**Comments on any additional submissions received by Deadline 6**  
**ELMESTHORPE PARISH COUNCIL**  
**27<sup>th</sup> February 2024**

**2. 6.2.8.1D Hinckley NRFI ES Appendix 8.1 Transport Assessment (Part 15 of 20) Sustainable Transport Strategy and Plan Rev 8**

- 2.4. More specifically, referring to appendix 4 Cycle Routes Options Tables (**6.2.8.1D Hinckley NRFI ES Appendix 8.1 Transport Assessment (Part 15 of 20) Sustainable Transport Strategy and Plan (Appendices) Rev 7**):

Enhancement 3: Improved crossing facility on the B581 linking Wilkinson Lane and Bridle Path Road via B581
Connectivity between A47 and Bridle Path Road via B581

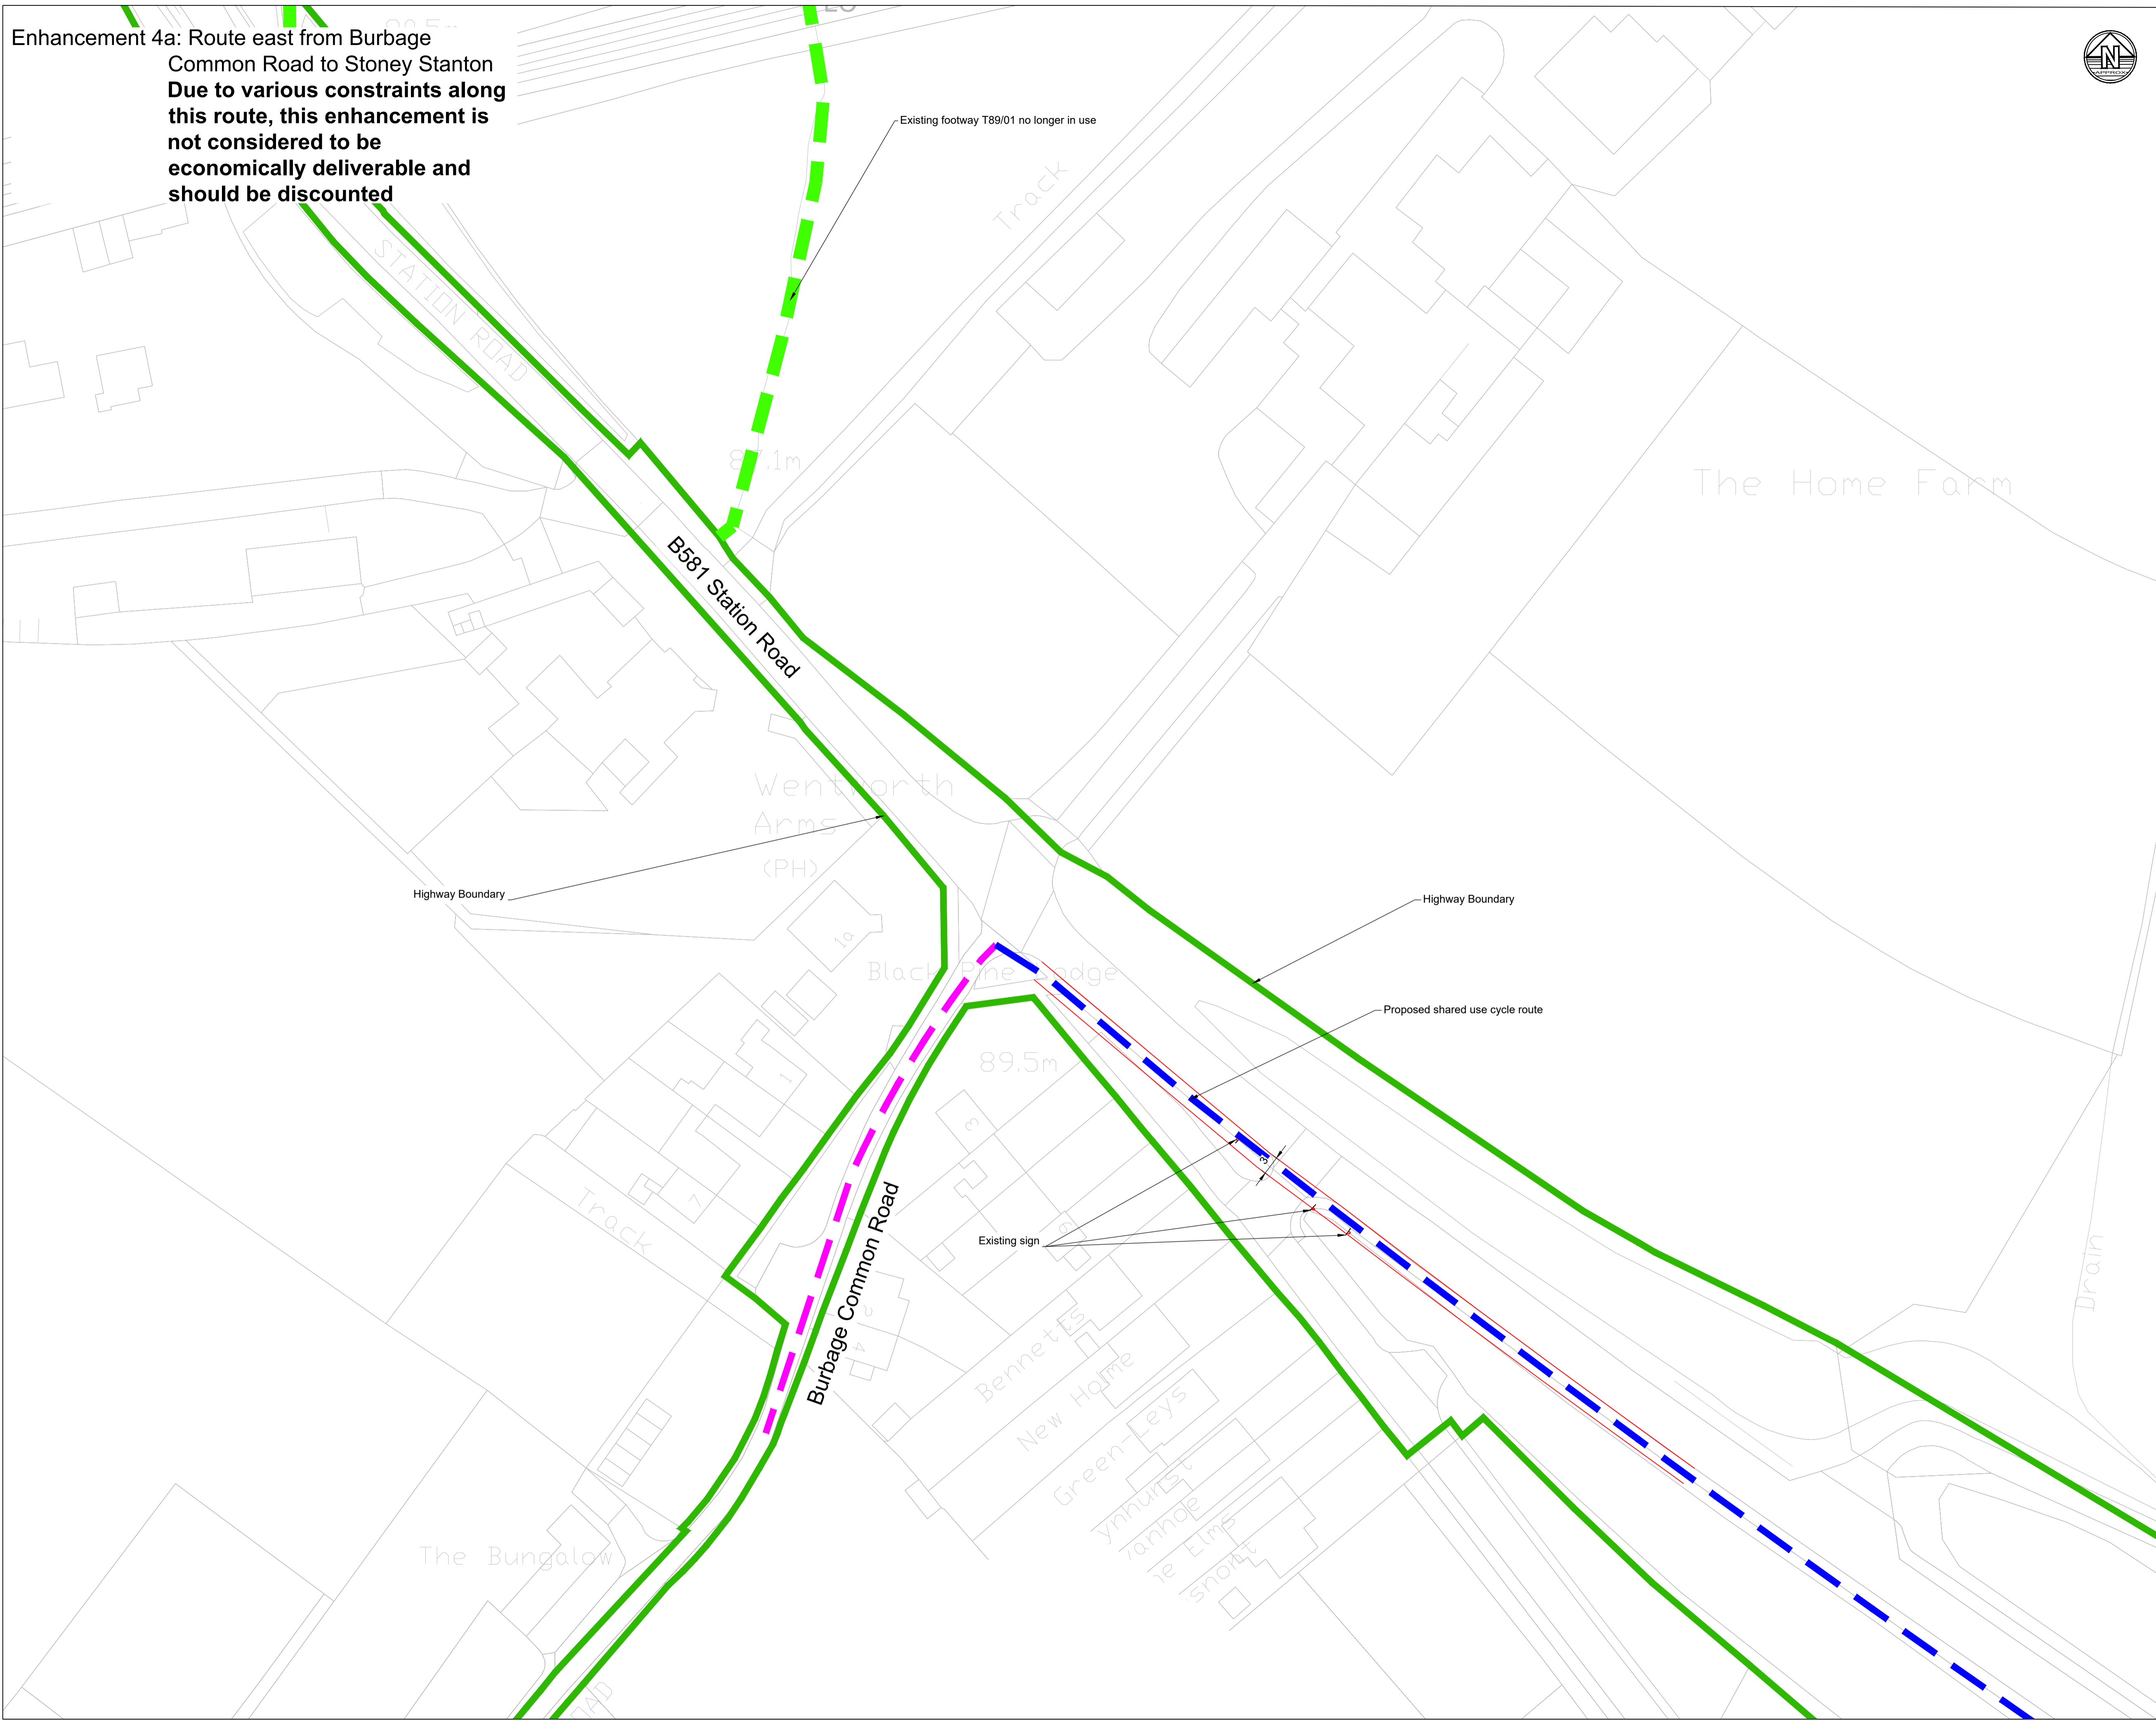
- 2.7. Enhancement Number 3: 'Provision of formalised crossing between Wilkinson Lane and Bridlepath Road Provision of shared footway/cycleway between Bridlepath Road and A47.' This enhancement consideration has been dismissed for various reasons. We appreciate that within the timescales available that this enhancement is unlikely to be reconsidered. Whilst we don't deem this enhancement necessary and agree with the dismissal, in the event that this enhancement is revisited, we would recommend the Applicant engages with Elmesthorpe Parish Council. There are alternative solutions within the same footprint which offer the same benefits and connectivity with less cost, disruption, inconvenience and green land usage. We would also like to remind the Applicant that Bridlepath Road is a privately owned road.
